From: Martin Hill <Martin.Hill@arun.gov.uk>
Sent: 02 November 2020 11:14
To: Planning.Responses <Planning.Responses@arun.gov.uk>
Subject: RE: Planning Consultation on: BR/222/20/PD

Please see comments from Private Sector Housing below, in respect of Gordon House, Bognor Regis.

Application No: BR/222/20/PD

Description of Works: Prior Approval under Schedule 2, Part 20, Class AA of the town and Country Planning (General Permitted Development) (England) Order 2015 (as amended) for an additional 5th storey providing a total of 17 No. flats.

PROPOSED 4TH FLOOR PLAN
Scale 1:200

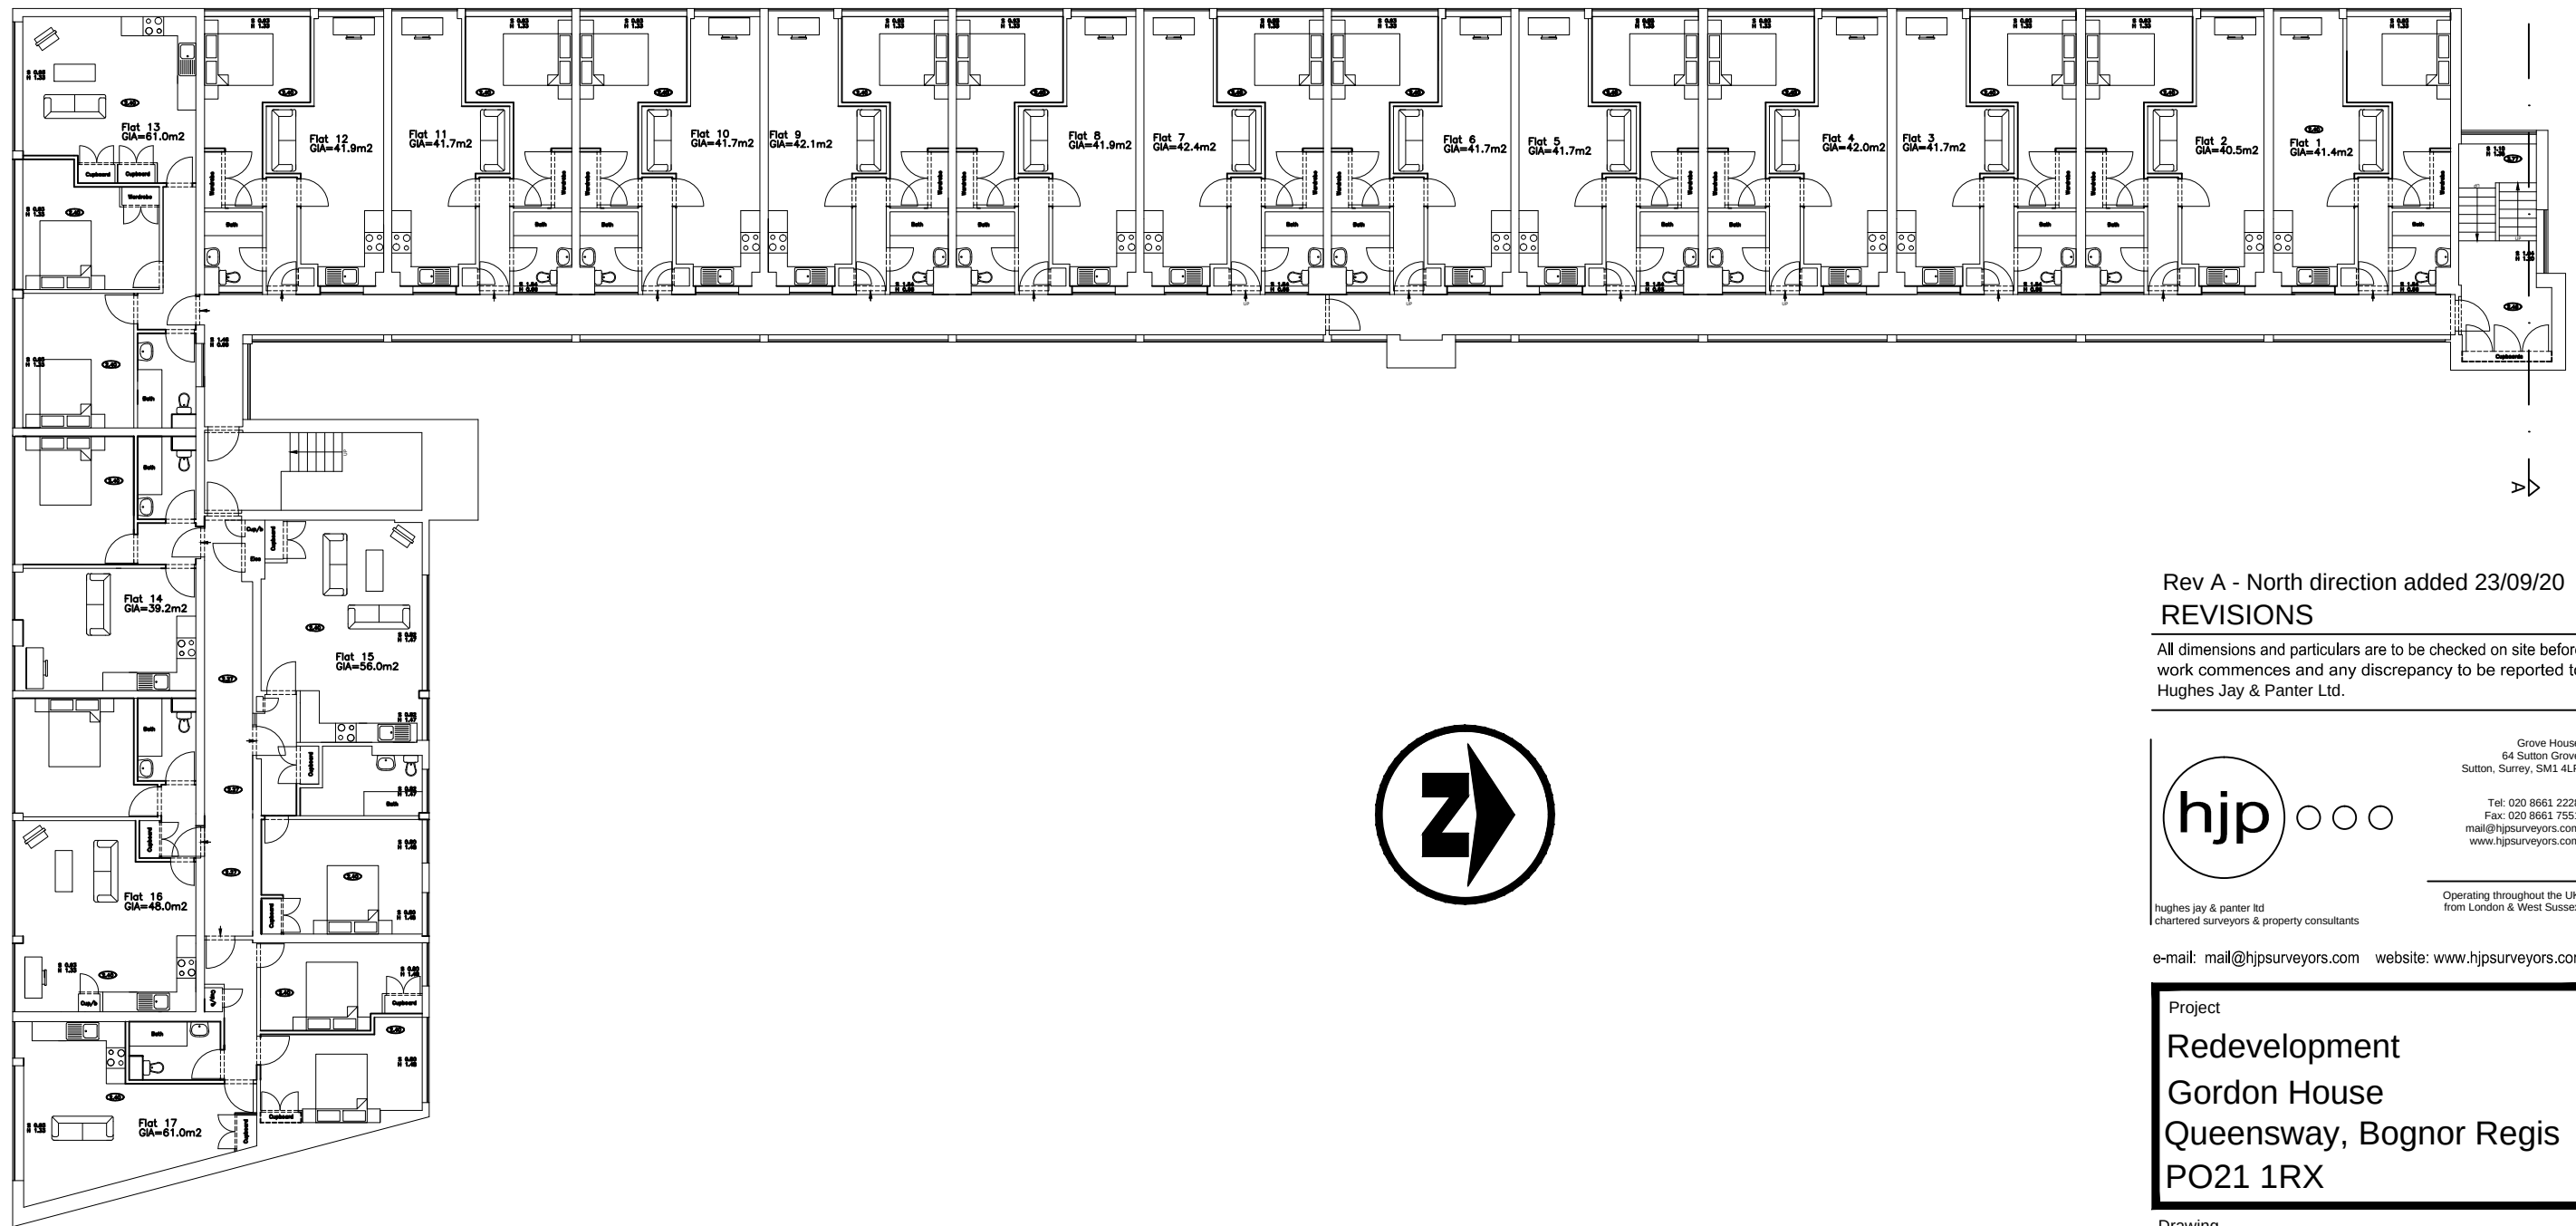
- An openable vent must be installed at the head of each stairway of the new storey for smoke control purposes.
- There is a dead end condition in the elevation where Flats 14, 15, 16 & 17 are to be situated. The travel distance in this corridor should not exceed 7.5 metres to the staircase.
- Escape corridors in excess of 30 metres should be sub-divided with cross-corridor doors
- All windows and elements of flat frontages facing in to the internal escape corridor must be fire-rated, must not be openable (with the exception of the entrance door) and facilities must not vent into the escape corridor.
- Emergency lighting must be installed in the escape route (corridor and staircase).
